PROJECT NAME: <i>OSPREY SOLAR FACILITY</i>	MAP NUMBER:
SITE ADDRESS: <i>3012 HWY 97 ELLENSBURG, WA 98926</i>	GENERAL LOCATION: <i>INTERSECTION OF HWY10/97 PARCEL # 346233</i>
AUTHORIZED AGENT/ CONTACT PERSON (Indicate who is the agent to be contacted for questions and meeting scheduling). <i>GIA CLARK</i>	PHONE: <i>206.922.7072</i>
MAILING ADDRESS: <i>101 YESLER WAY, SUITE 401 SEATTLE, WA 98104</i>	Fax #:
COMPANY NAME: <i>ONEENERGY RENEWABLES</i>	E-MAIL: <i>GIA@ONEENERGYRENEWABLES.COM</i>
DESIGN PROFESSIONAL IN CHARGE OF PROJECT: <i>MARK KELLER</i>	PHONE: <i>509.933.2479</i>
MAILING ADDRESS: <i>421 N. PEARL ST., SUITE 206 ELLENSBURG, WA 98926</i>	Fax #:
COMPANY NAME: <i>CENTURY WEST ENGINEERING</i>	E-MAIL: <i>MKELLER@CENTURYWEST.COM</i>
PROPERTY OWNER: <i>TAYLOR RANCHES, LLC</i>	PHONE:
MAILING ADDRESS: <i>3012 HWY 97 ELLENSBURG, WA 98926</i>	E-MAIL:

# SECTION 2: Pre-Application Meeting Worksheet

8/27/14 2nd PRE-AP

| GRADING PLAN | SHEET NO. 3 OF 5 |

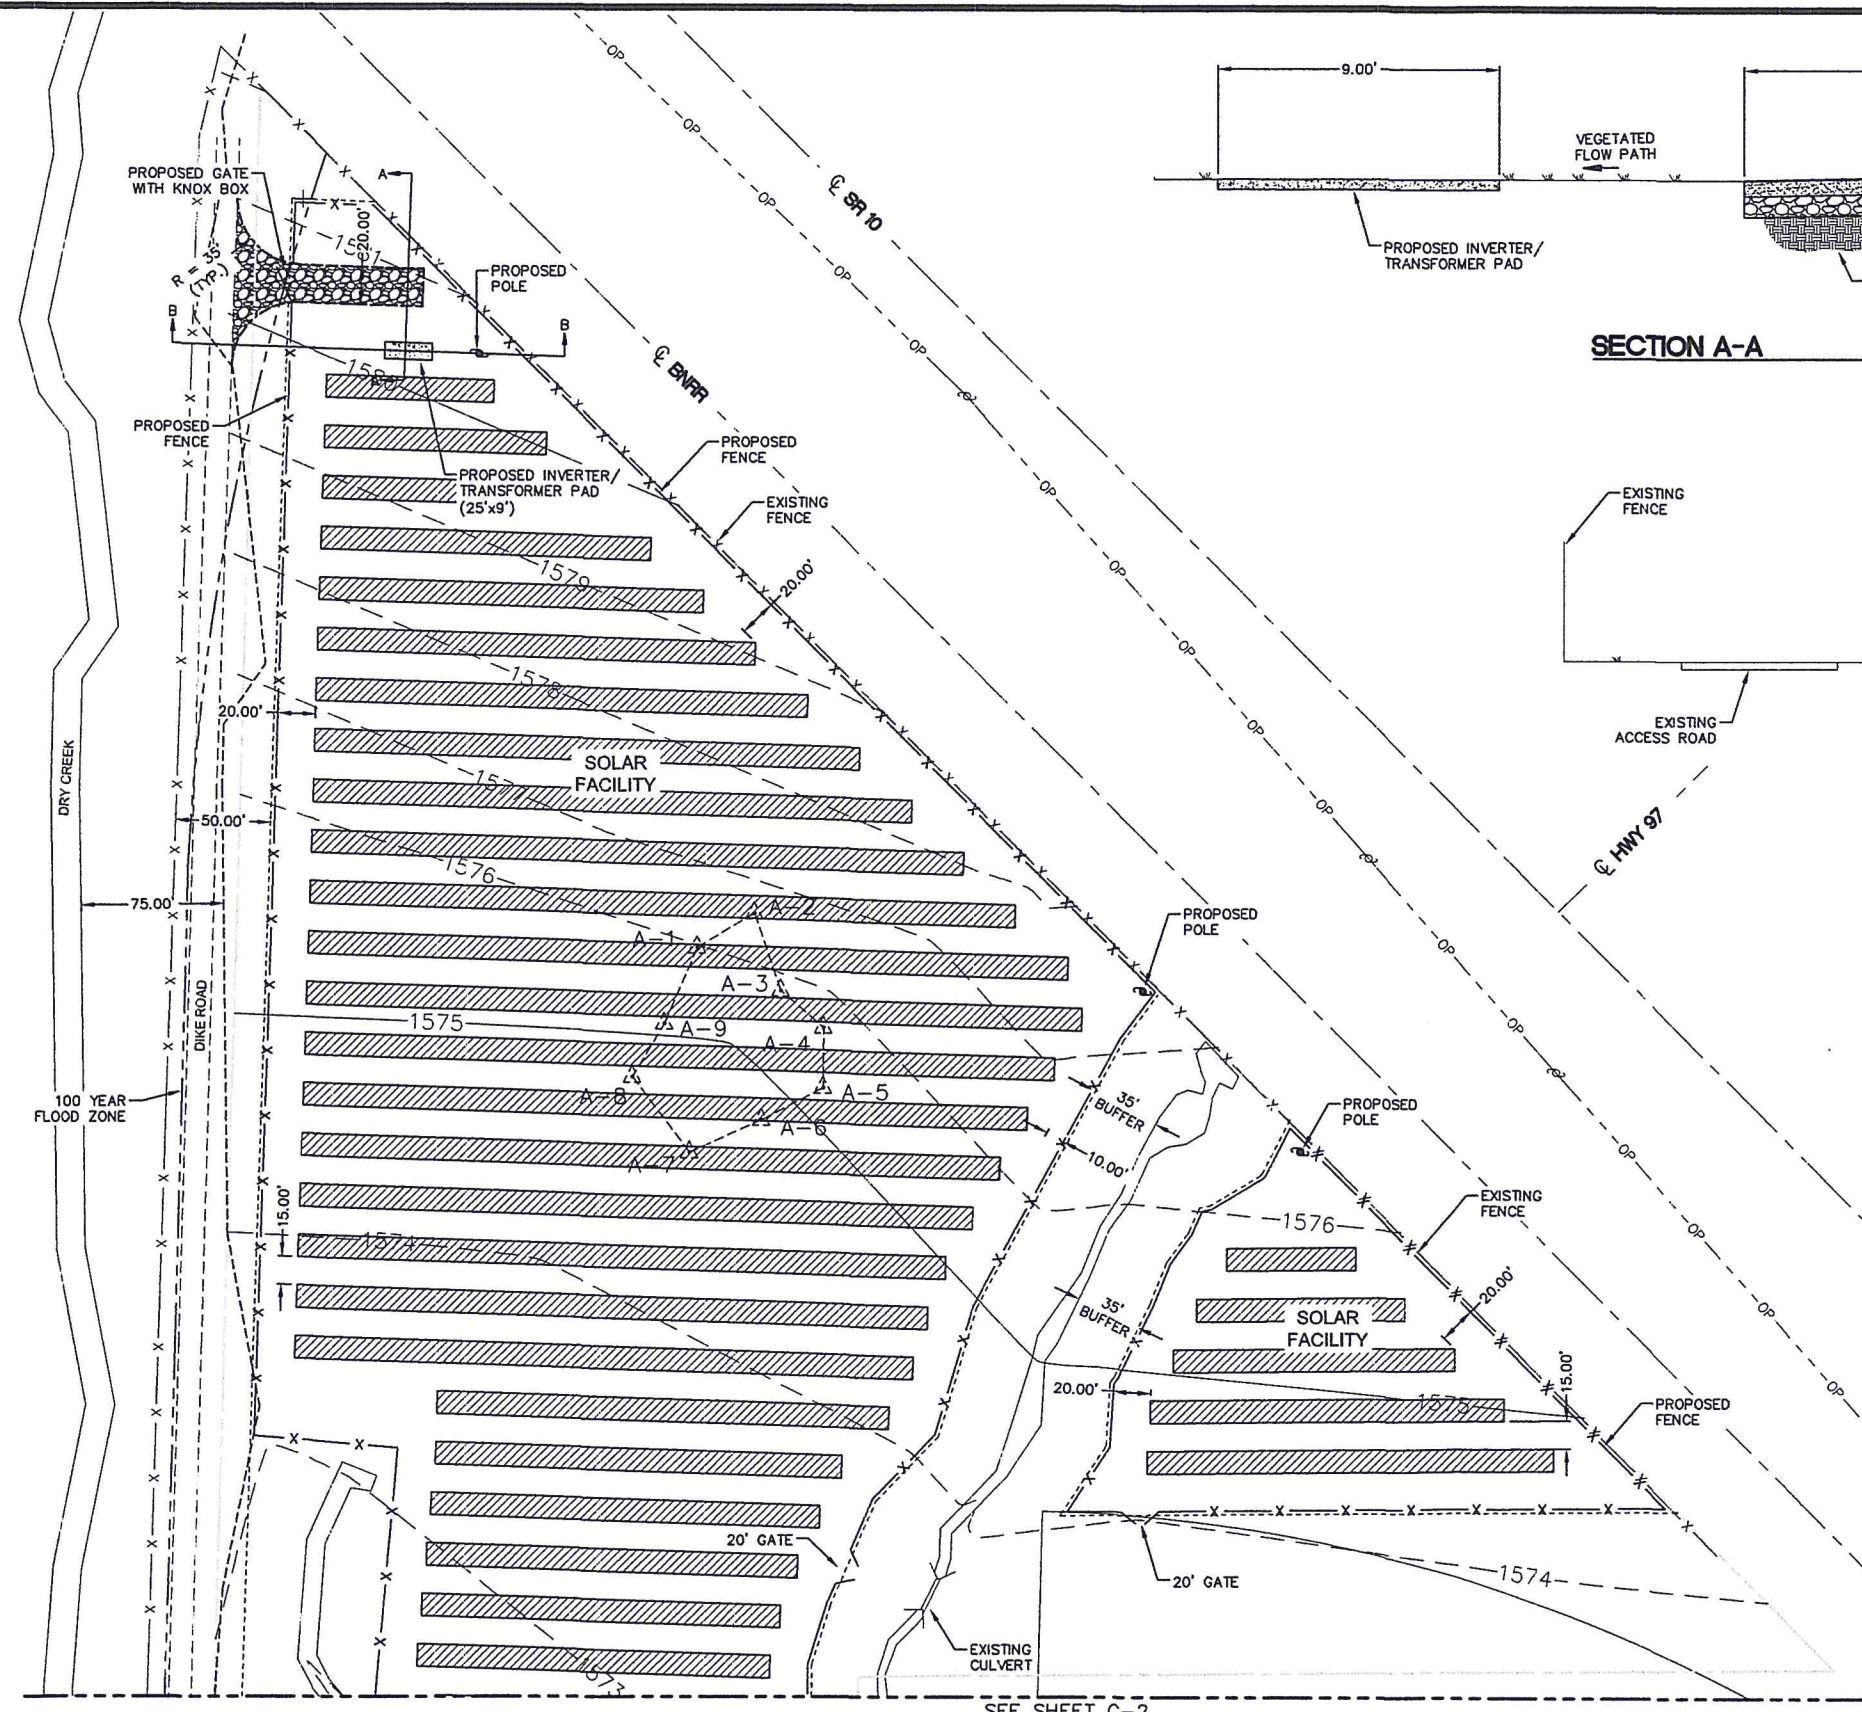
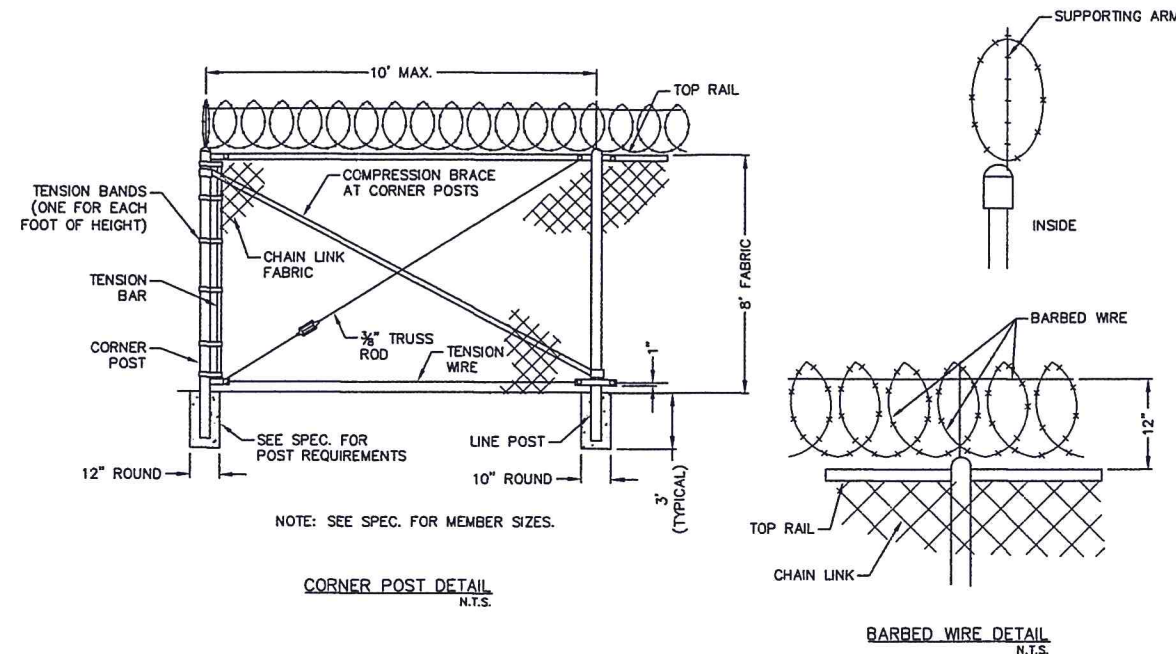
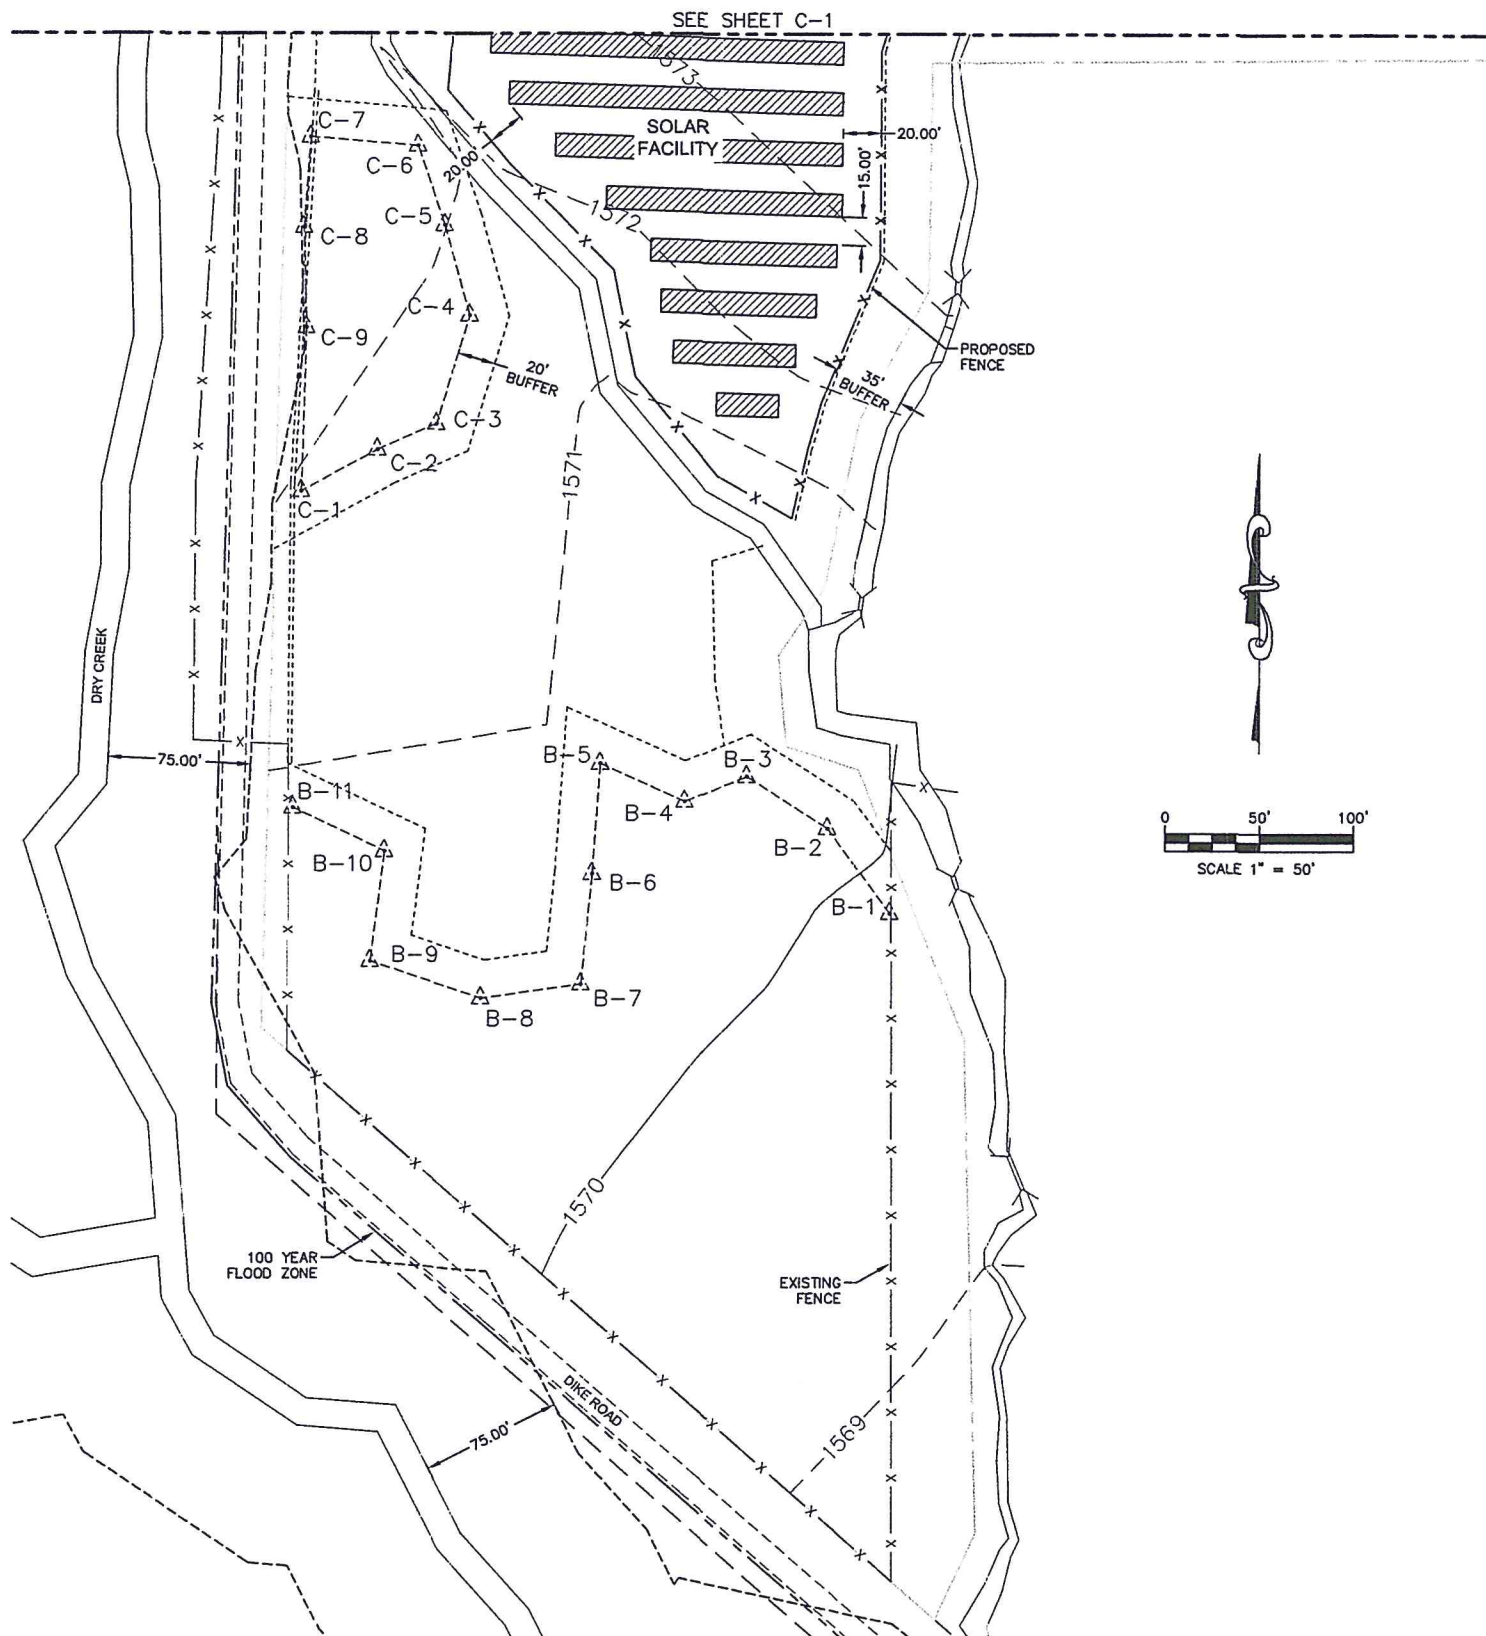
Comments: 20' WIDE SURFACE REQUIRED AROUND ENTIRE PROJECT FOR EMERGENCY ACCESS. DOUBLE 10' GATES REQUIRED BETWEEN SOLAR FIELDS.

Comments: Internal roads to be constructed to Fire Marshal standards. Stormwater to be designed by licensed engineer, reviewed by county engineer and/or WSDOT. Construction to be certified by licensed engineer prior to final approval. Transportation concurrency req'd. Exempt access permit req'd, WSDOT access, railroad permit req'd. Flood permit req'd if any part of project within floodplain.
